Consultation Response from KC, Conservation & Design**2023/90487 1,3,5,7, Oates Street, Dewsbury, WF13 1BB****Erection of extensions and re-building of derelict buildings to form 5 flats (within a Conservation Area)****Date Responded: 18.5.2023****Responding Officer: Sue Brooks****Responding Ref:**

PROPOSED FRONT ELEVATION
SCALE - 1:100
(Flat No.4 & No.5)

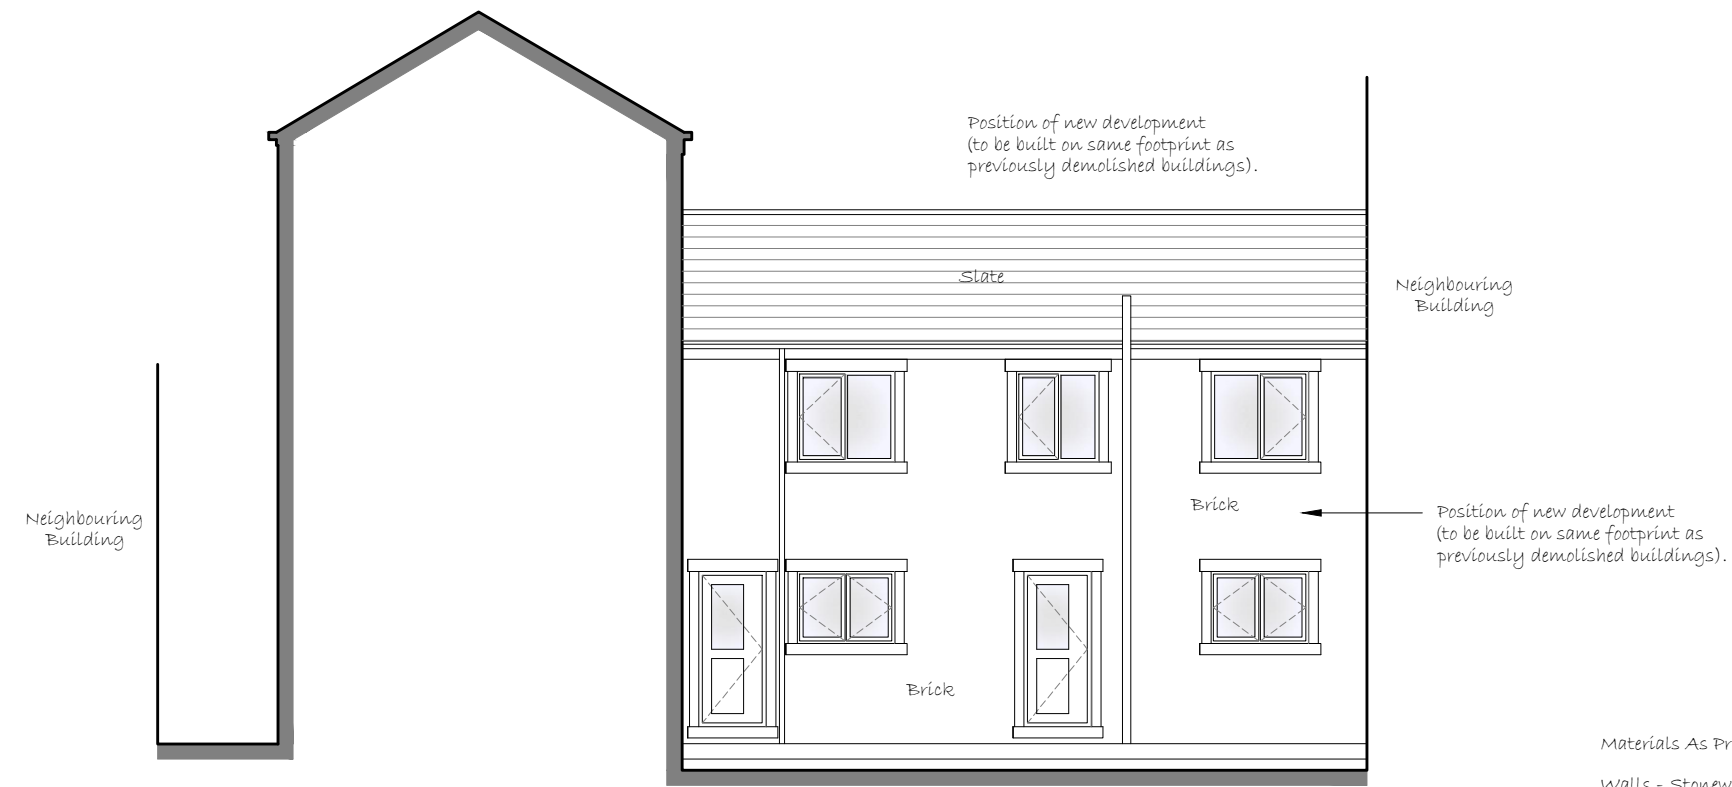
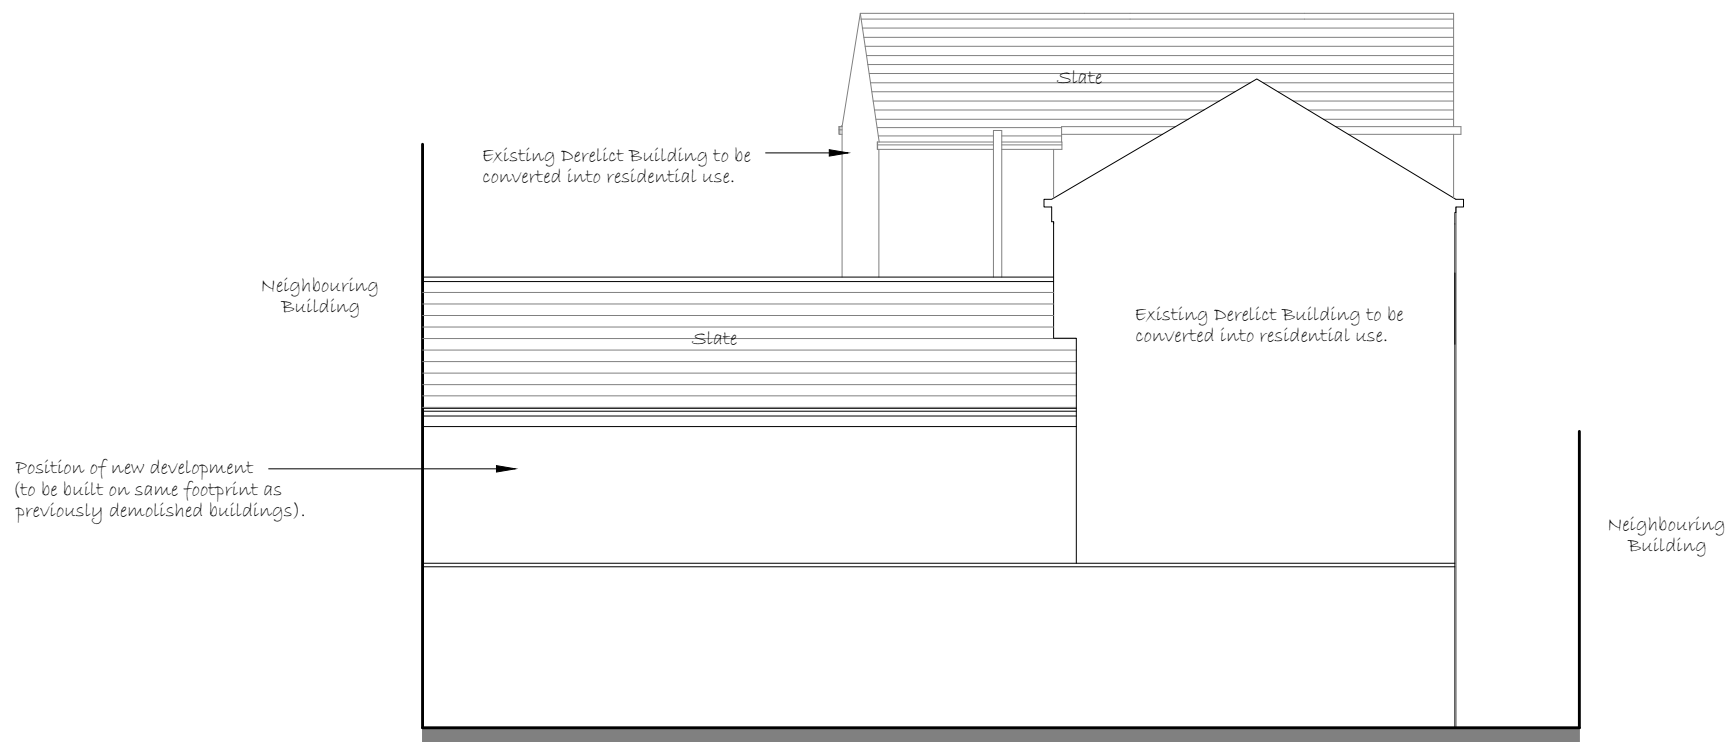
The proposed new building at the rear of the site is vernacular in design and constructed in traditional materials. We have no objection to brickwork for the side and rear elevations, although we would prefer natural stone for the façade as this is more typical of the principal elevations within the locality and the building that was previously on this site.

- External material samples submitted for approval.
- Window and door surrounds of the new building shall be in sawn natural stone to match the existing cills and lintols on the façade of the existing building.
- Gutters on the façade of the new building shall be set onto stone gutter corbels instead of fascia boards, unless otherwise agreed by the LPA.
- Elevations and sections of doors and windows, along with their colour and finish, submitted for approval,
- Details of the proposed gates shall be submitted for approval.
- The brick boundary wall shall be topped with stone copings of no less than 75mm thick.
